R-2511 4B Interagency Concurrence Point Meeting Minutes

Date: April 18, 2018

The 30% Hydraulic Review was held in order to reach agreement on concurrence point 4B for the R-2511 US-17 widening project in Beaufort and Martin Counties. The following items were discussed and conclusions reached:

PROJECT REFERENCE NO. R-2511		SHEET NO. 10	
RW SHEET NO.		HYDRAULICS ENGINEER	
ROADWAY DESIGN ENGINEER		SCOTT D. BLEVINS 1/18/2022	
DOCUMENT NOT CONSIDERED FINAL UNLESS ALL SIGNATURES COMPLETED

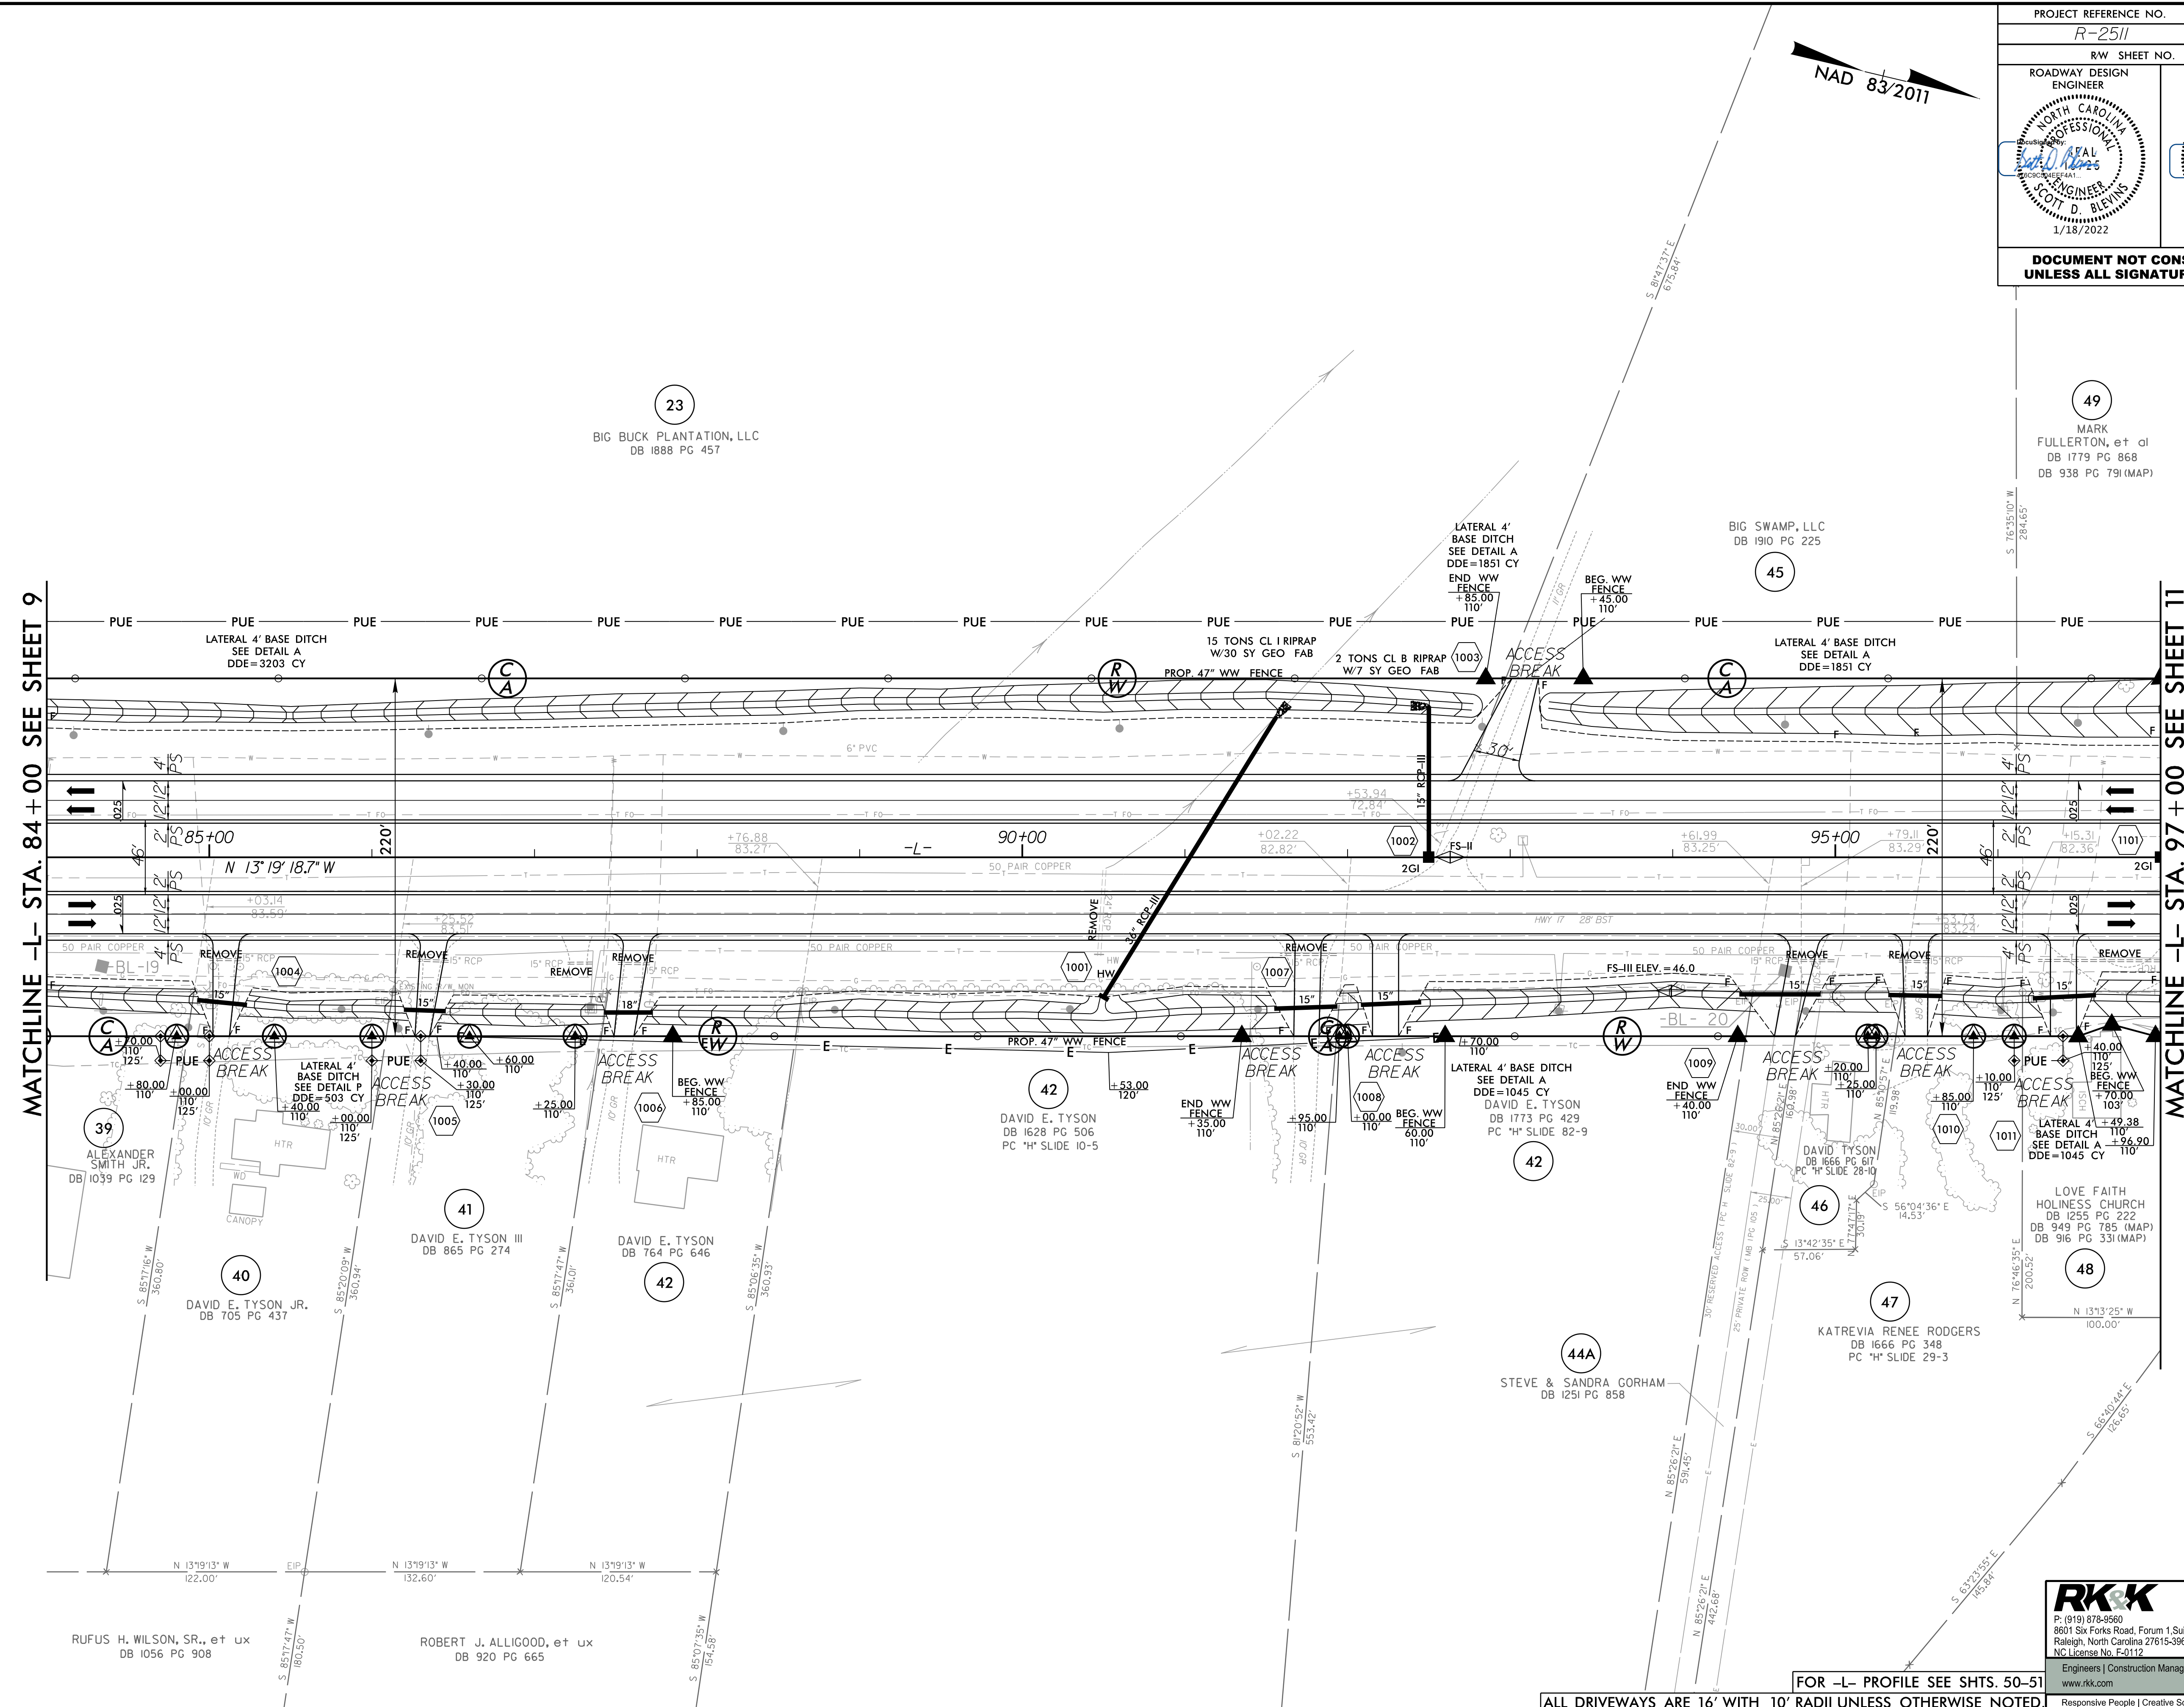
Plan sheet 11 (Stream UT to Latham Creek SJ): Stream SJ runs east to west through the project and is currently conveyed in a 24" RCP at -L- 99+00. This crossing is identified in USGS and soil survey mapping and is only identified as jurisdictional on the downstream end of the crossing in the JD. With the crossing being in the Tar-Pamlico River Basin the proposed lateral swales entering the stream must meet the design criteria for buffer filtration. There will be stream impacts on the downstream end of the crossing due to the widening. The 24" RCP will be removed and 2 @ 42" RCPs-III not buried will be installed in the final condition. This will be called out as Site 4. Mr. Ward and Mr. Barnes stated that they will be going back to this site to do field verification for the JD.

PROJECT REFERENCE NO. R-2511	SHEET NO. 25
RW SHEET NO.	
ROADWAY DESIGN ENGINEER NORTH CAROLINA PROFESSIONAL SEAL COIT D. BLEVINS 1/18/2022	HYDRAULICS ENGINEER NORTH CAROLINA PROFESSIONAL SEAL ROBERT B. HUSKEY 1/18/2022
DOCUMENT NOT CONSIDERED FINAL UNLESS ALL SIGNATURES COMPLETED

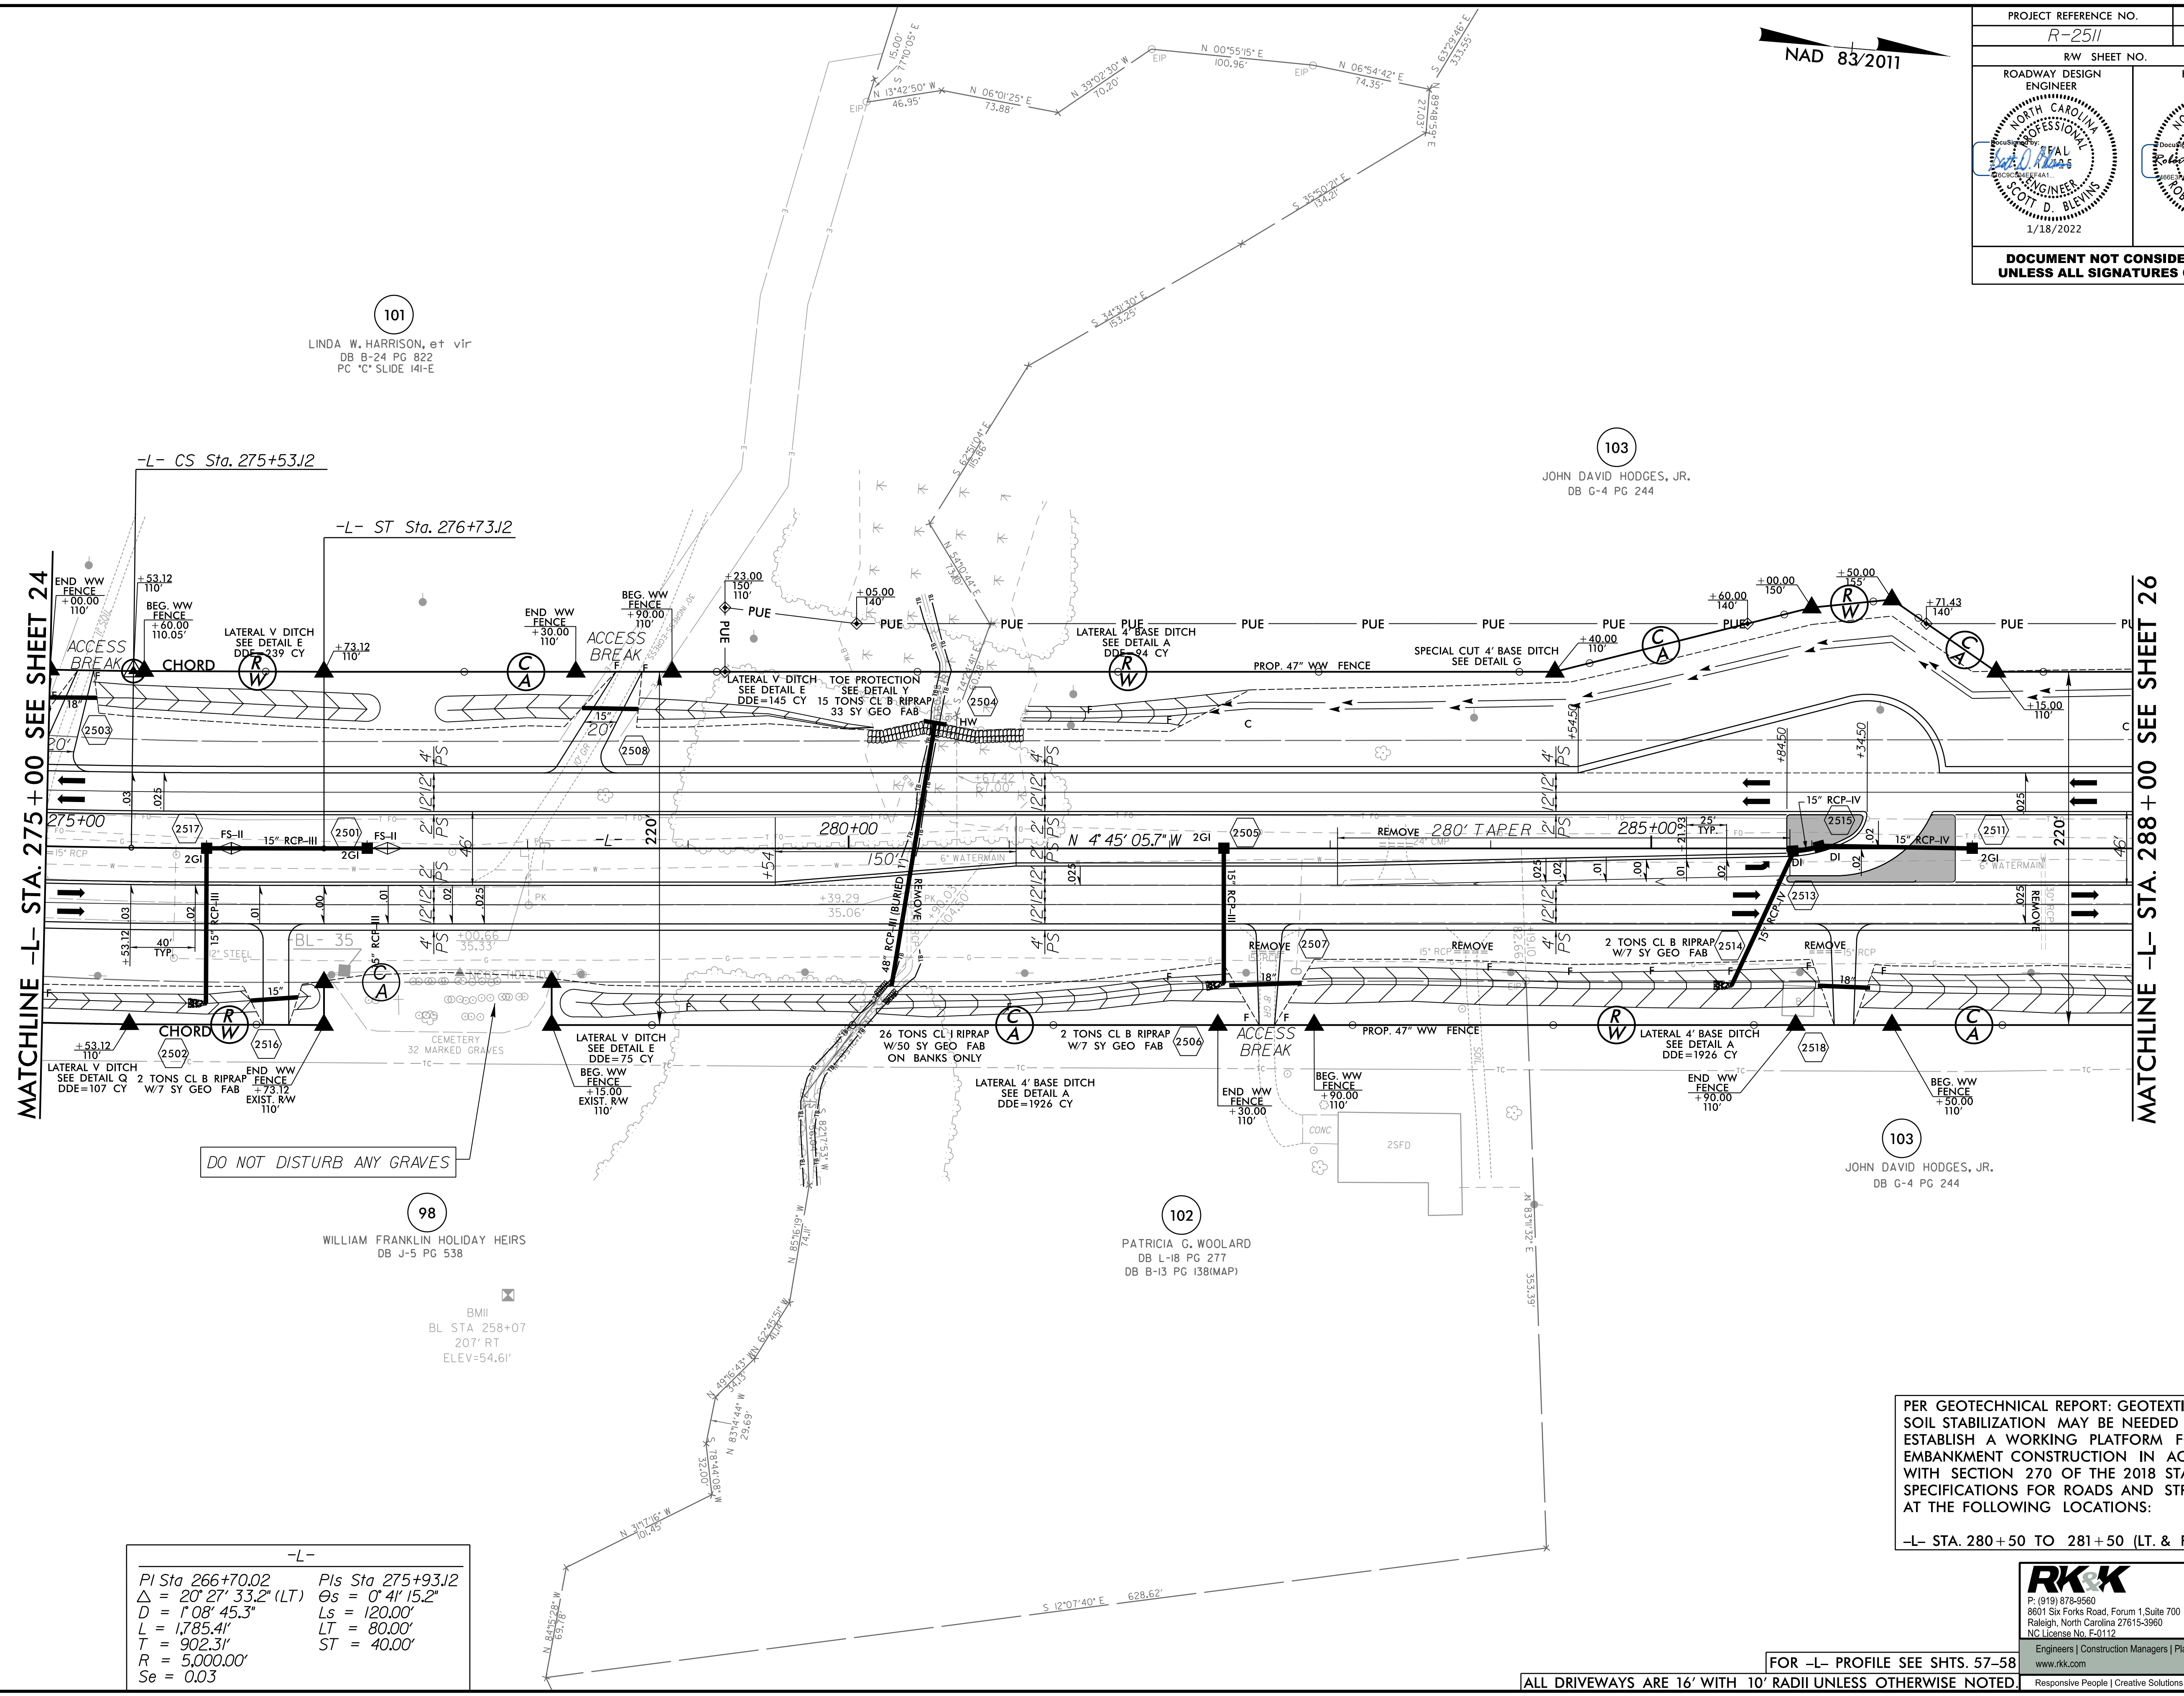
Plan sheet 25 (Stream UT to Smithwick Creek SD, wetland WE): Stream SD runs west to east through the project and is currently conveyed in a 30" RCP at -L- 280+40. This site and the rest of the sites on the project will be in the Roanoke river basin which does not require buffer filtration. There will be stream impacts on the up and downstream end of the crossing as well as wetland impacts to the upstream side of the crossing due to the road widening. The 30" RCP will be removed and replaced with a 48" RCP-III buried 0.8' in the final condition. This will be called out as site 7.
